From: [Wolfenbarger, Jeanne](#)
To: ["aeclic@aol.com"](mailto:aeclic@aol.com)
Subject: LOT 17-A-@, Pappe Addition (G14-D087)
Date: Monday, November 03, 2014 11:25:50 AM
Attachments: [Scanned from a Xerox multifunction device.pdf](#)

Shawn, I have received the updated site plan for the subject project but still have the following comments:

3440 2ND STREET, NW SITE PLAN FOR BUILDING PERMIT

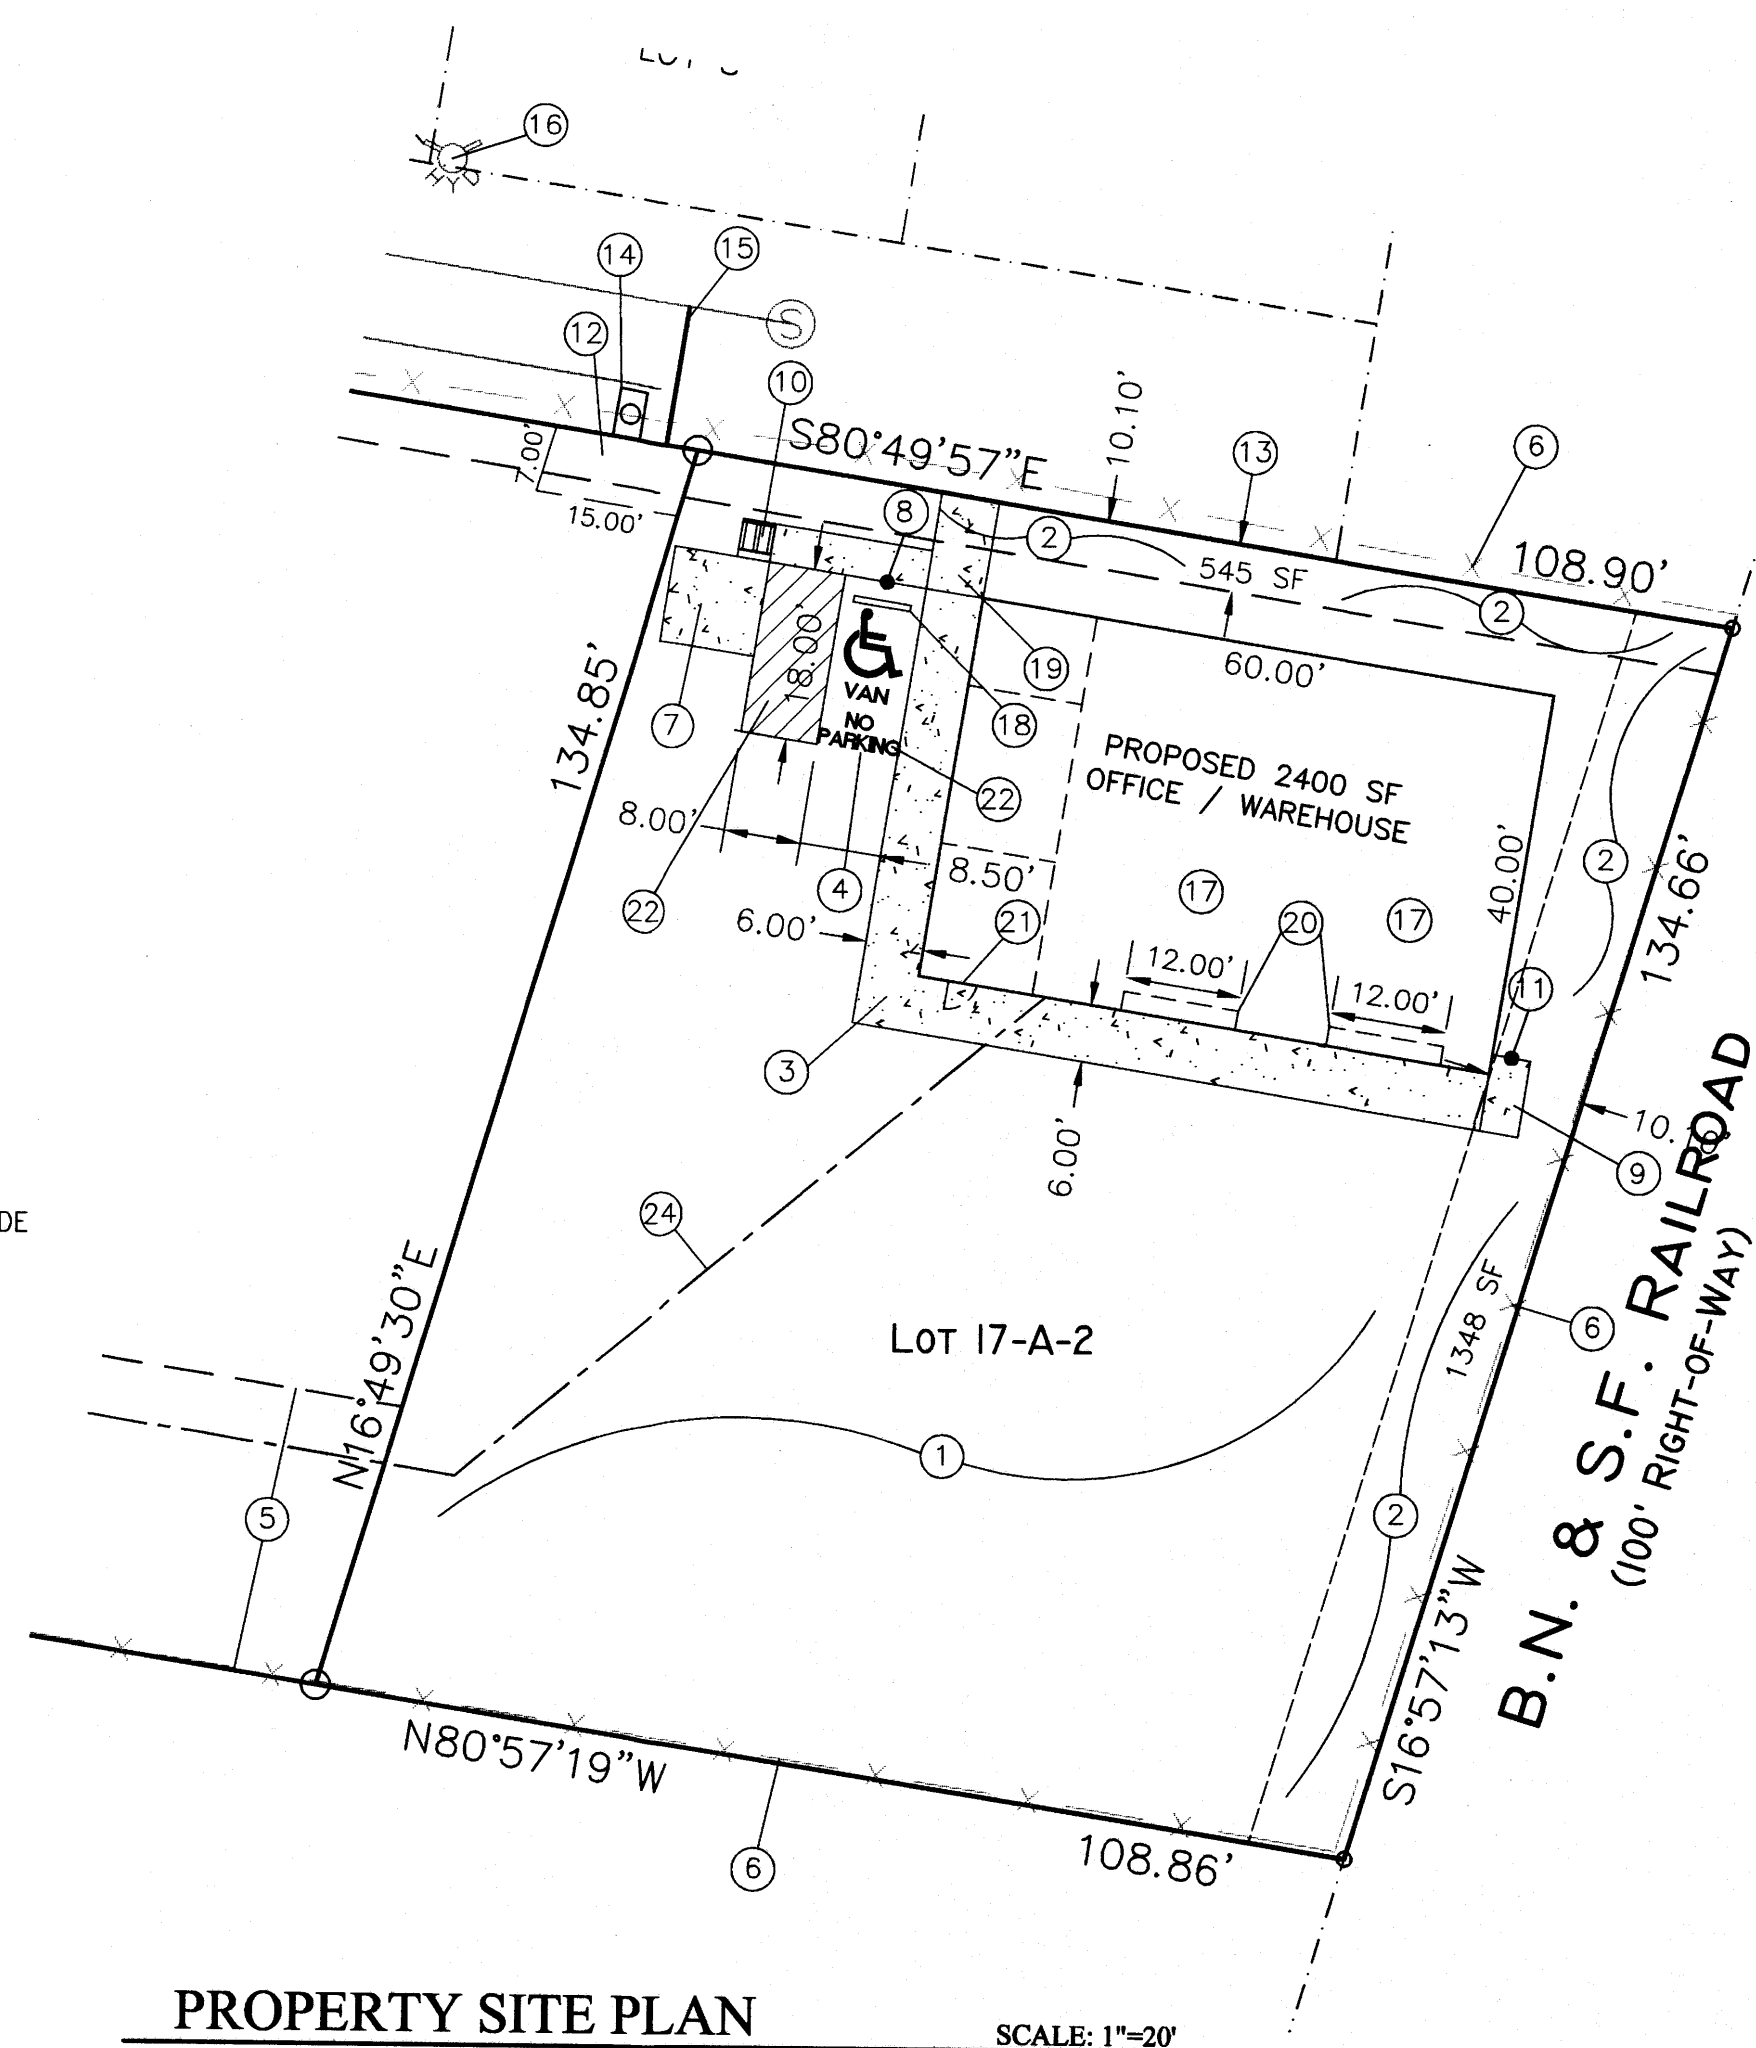
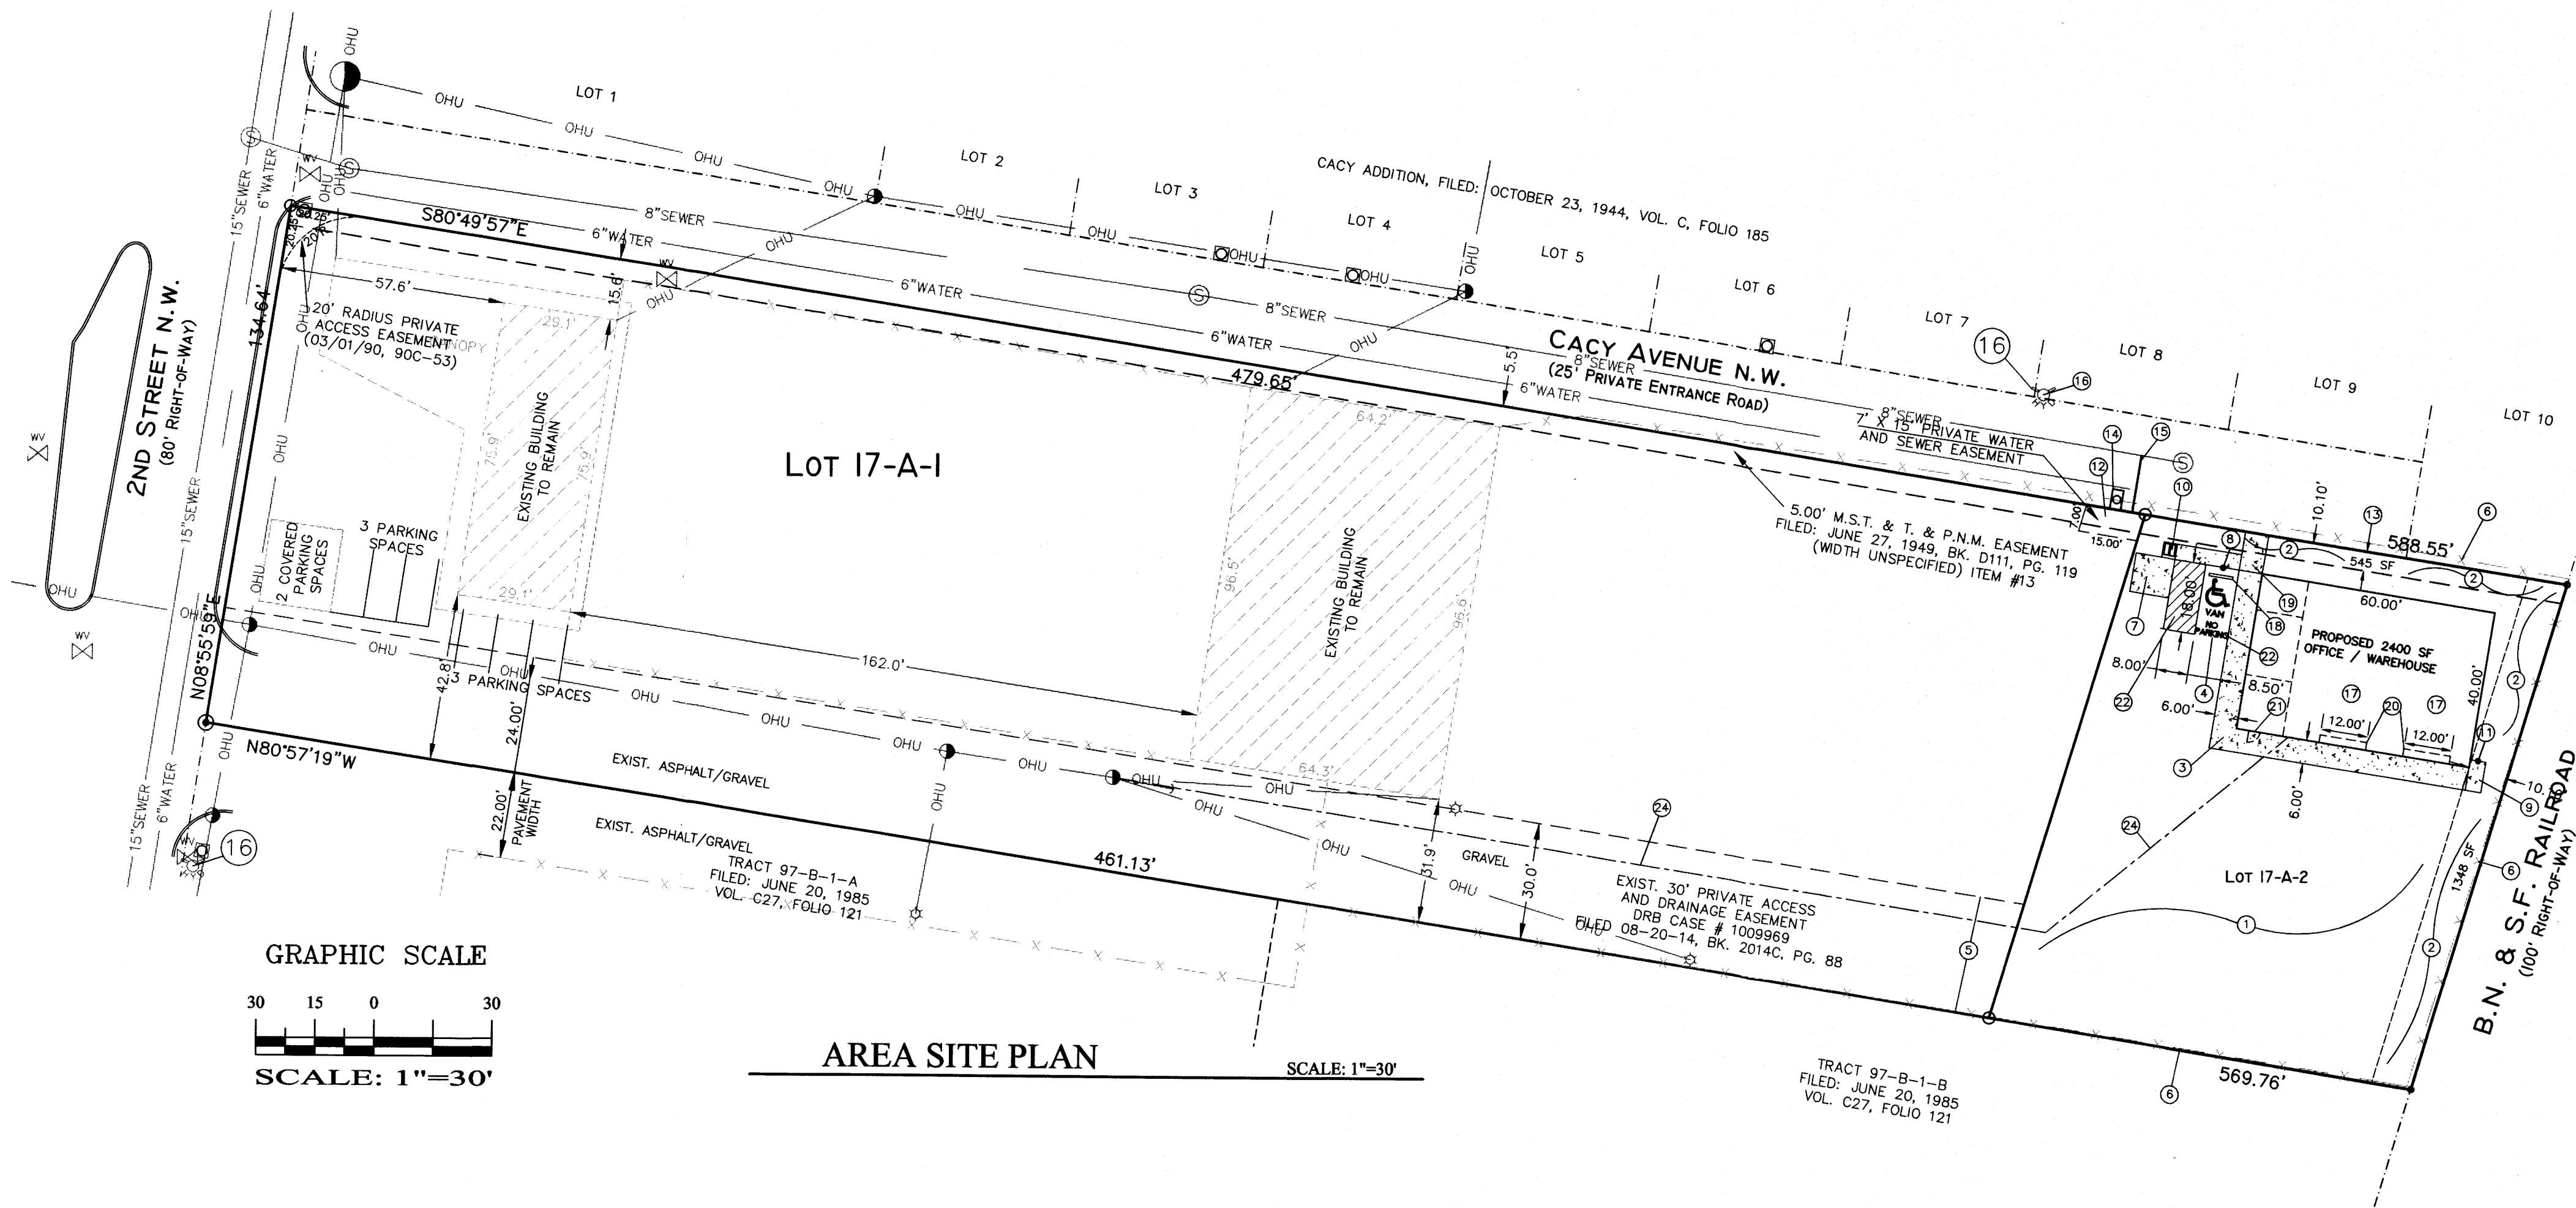
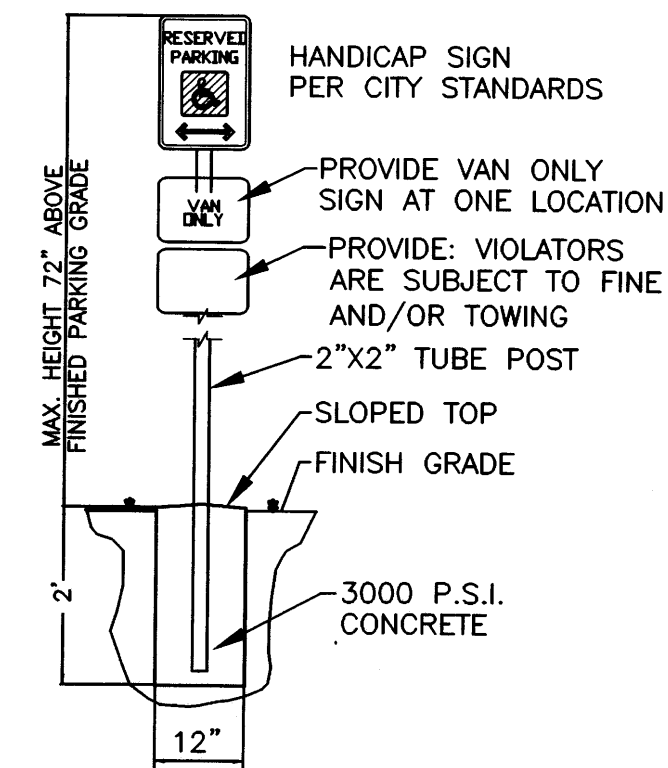
1. I do not see Keyed Note 23 on the plans. I think you meant to put in Keyed Note 23 where keyed note 22 is shown for the van accessible space.
2. The site plan needs to be clear that both the van accessible space and the handicapped space are asphalt. Right now only the handicapped space is shown to be asphalt. It may be more clear if some type of hatching/lineweights are shown to differentiate the asphalt area from the remaining area.
3. The "No Parking" words need to be placed in the van accessible aisle, not where the handicapped people park (See attached scan).
4. Also see the attached scan for exact required language on the handicap sign. The "van only" sign needs to be shown as "van accessible".
